# DeYOUNG SUBDIVISION Construction Drawings El Paso County, Colorado

**PCD PROJECT NO. MS-20-001**

**TITLE SHEET**

**PHASE 1 - SITE GRADING & EROSION CONTROL PLAN**

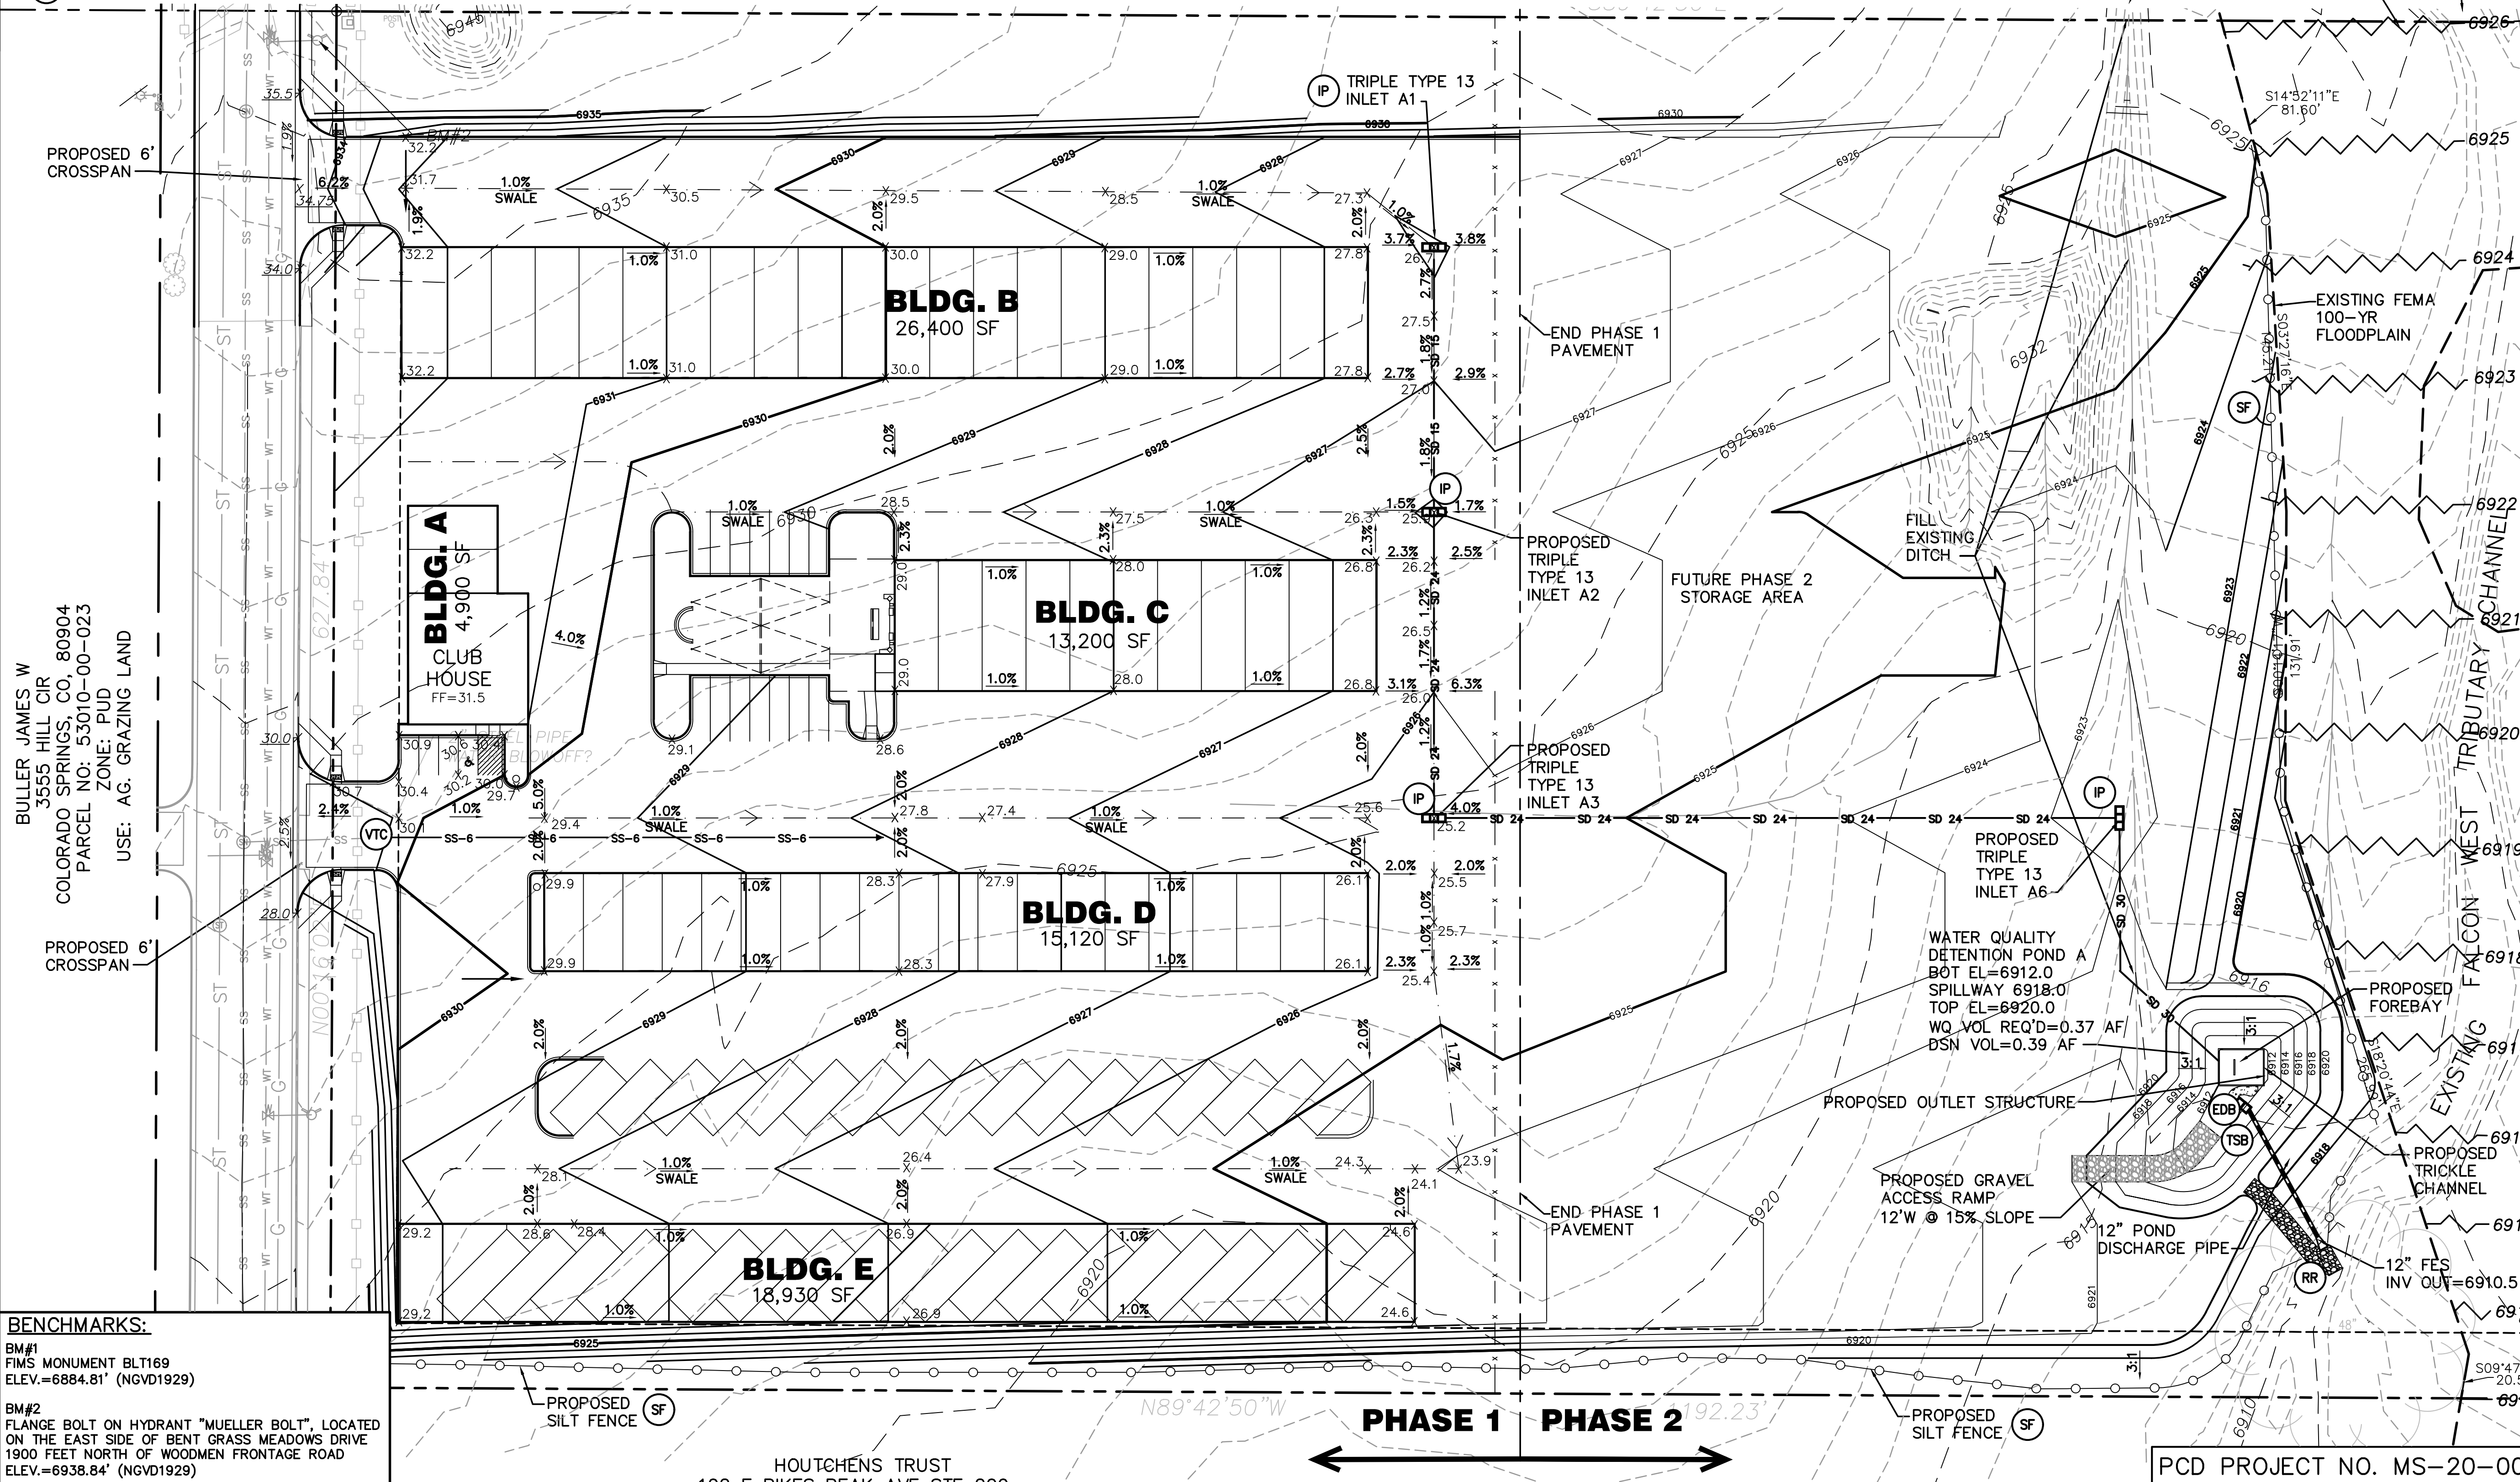
- Add the following:
- limits of disturbance
  - construction site boundary
  - cut/fill lines
  - note about existing vegetation %
  - add a note that no asphalt/concrete batch plant will be utilized during this project

<b>(VTC)</b> VEHICLE TRACKING CONTROL PAD		PROPOSED PROPERTY LINE
<b>(SF)</b> SILT FENCE		EXISTING CONTOURS
<b>(SM)</b> SEED & MULCH		PROPOSED CONTOURS
<b>(CWA)</b> CONCRETE WASHOUT AREA (TO BE COMPLETELY CONTAINED & REMOVED UPON COMPLETION OF PROJECT)		EXISTING SPOT ELEVATIONS
<b>(IP)</b> INLET PROTECTION		PROPOSED SPOT ELEVATIONS
<b>(RR)</b> RIPRAP APRON		PROPOSED GRADES
<b>(SSA)</b> STABILIZED STAGING AREA		ROOF DRAIN DOWNSPOUTS; INSTALL TRANSITION COUPLINGS & CONNECT TO SITE STORM SEWER W/ 6" PVC SD LATERALS @ 1.0% MIN. SLOPE (COORDINATE W/ ARCH / MEP PLANS)
<b>(EDB)</b> EXTENDED DETENTION BASIN		show stormwater flow arrows
<b>(TSB)</b> TEMPORARY SEDIMENT BASIN		Show SM, CWA, and SSA locations on plan

Add VTC or block entrance from entering/exiting traffic

show slope. If slope is steeper than 3:1 erosion control blanketing is required

continue silt fencing

show slope. If slope is steeper than 3:1 erosion control blanketing is required
